M5 Junction 10 Improvements Scheme

dDCO Change Log
TR010063 - APP 9.21

Draft DCO Change Log

Regulation Number:	Regulation 5 (2) (b)
Planning Inspectorate Scheme Reference	TR010063
Application Document Reference	TR010063/APP/9.21
Author:	M5 Junction 10 Improvements Scheme Project Team

Description	Status	Revision	Drawn	Checked	Reviewed	Authorised	Issue Date
NOT USED	A1	C01	YP	YP	YP	YP	02/07/24
AMENDMENT TO PROW FP AUC11	A1	C02	VN	CG	CJ	LJ	02/09/24

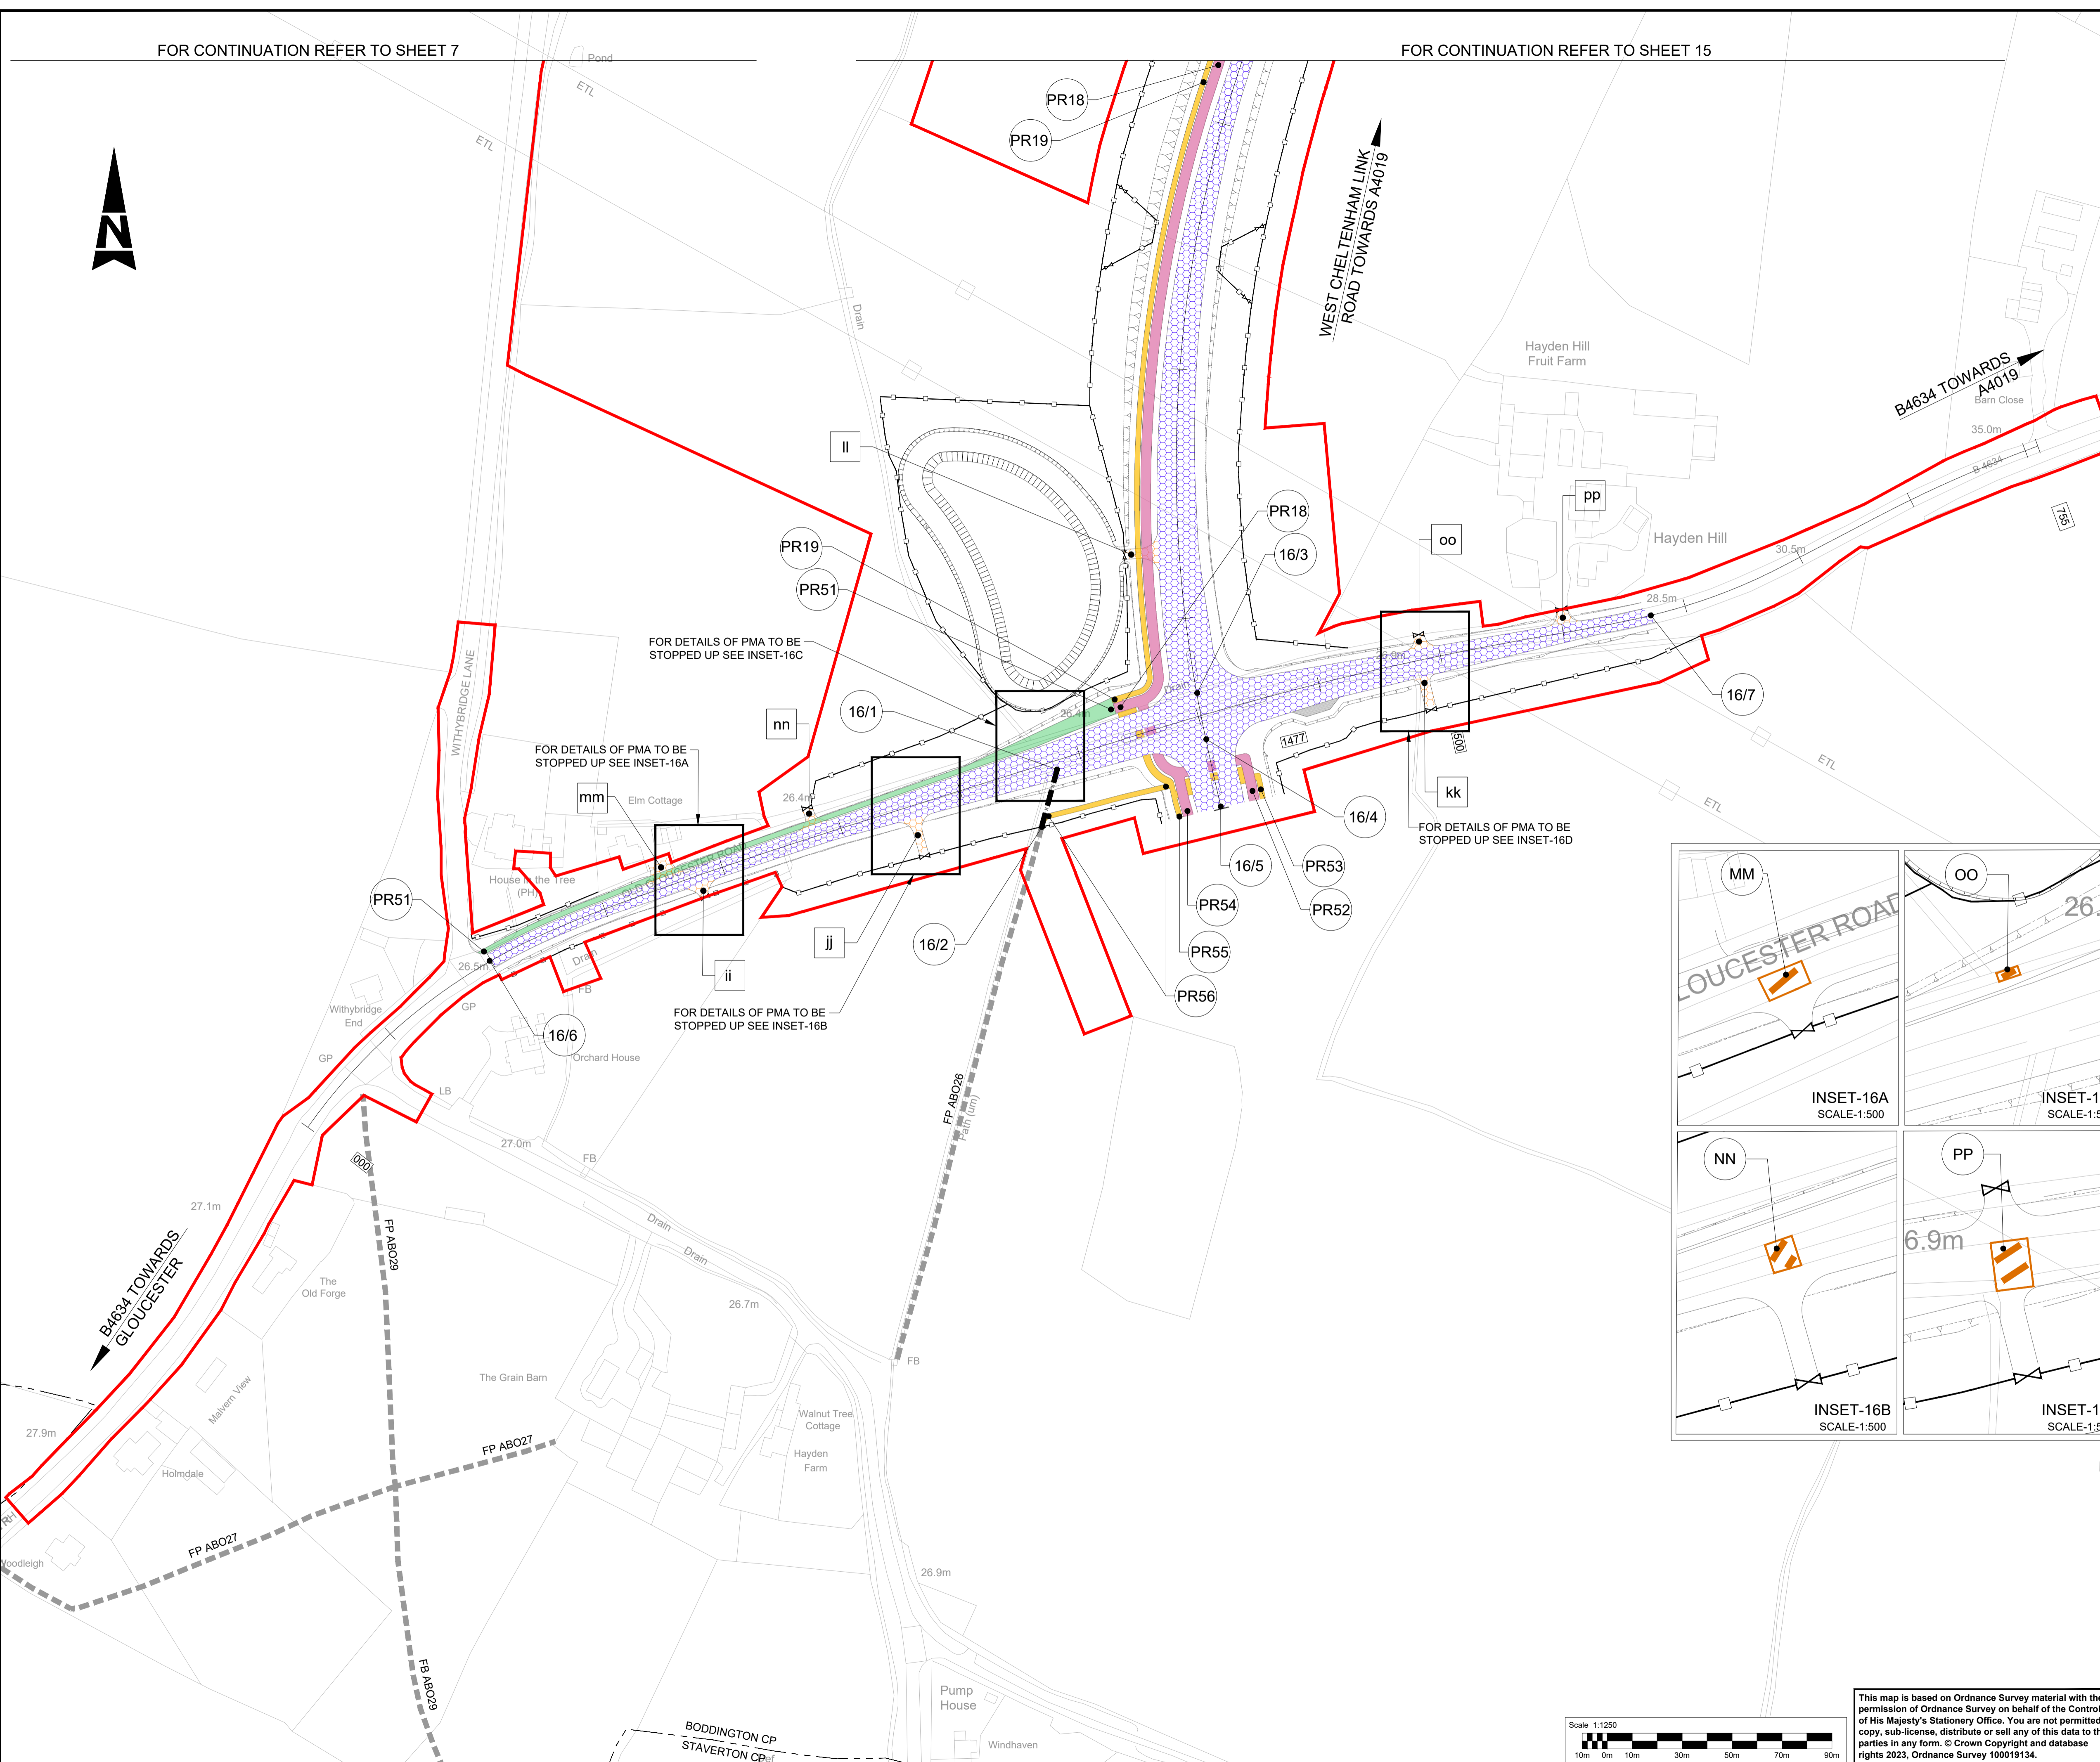
Schedule 3, Part 7	<p><u>PR49</u> 320-309 metres of footpath to the north of the River Chelt, rerouting the existing footpath ref. AUC11 under the new River Chelt Bridge, as shown on sheet 15 of the streets, rights of way and access plans</p>	To reflect changes made to the streets, rights of way and access plans which provide a minor realignment to the diverted public right of way.
Schedule 4, Part 2, Row 1	Column (3)	To reflect changes made to the streets, rights of way and access plans which provide a minor realignment to the diverted public right of way

<p>For a distance of 144<u>103</u> metres, as shown between points 15/1 and 15/2 on sheet 15 of the streets, rights of way and access plans</p> <p>Column (4)</p> <p>Reference PR49</p> <p>320<u>309</u> metres of new footpath to the north of the River Chelt, rerouting the existing footpath ref. AUC11 under the new River Chelt Bridge, as shown on sheet 15 of the streets, rights of way and access plans</p>	
Schedule 5, plot 3/2c	Removal of plot 3/2c to be inserted in Schedule 7	To align with changes to the Book of Reference, Statement of Reasons, Land Plans as a result of further engagement with National Highways.
Schedule 5, plot 4/1c	<p>New plot added to schedule which had been permanent acquisition. New rights required for work numbers 1a, 1c, 1e, 1n being:</p> <p><u>New right for the construction of motorway signage and associated cabling and ducting works</u></p> <p><u>New right for the construction of a new southbound exit slip from the M5 to the A4019</u></p> <p><u>New right for the construction of a new northbound entry slip from the A4019 to the M5</u></p> <p><u>New right for the construction of an environmental barrier adjacent to Barn Farm north of Junction 10 and west of the M5</u></p>	To align with changes to the Book of Reference, Statement of Reasons, Land Plans as a result of further engagement with National Highways.
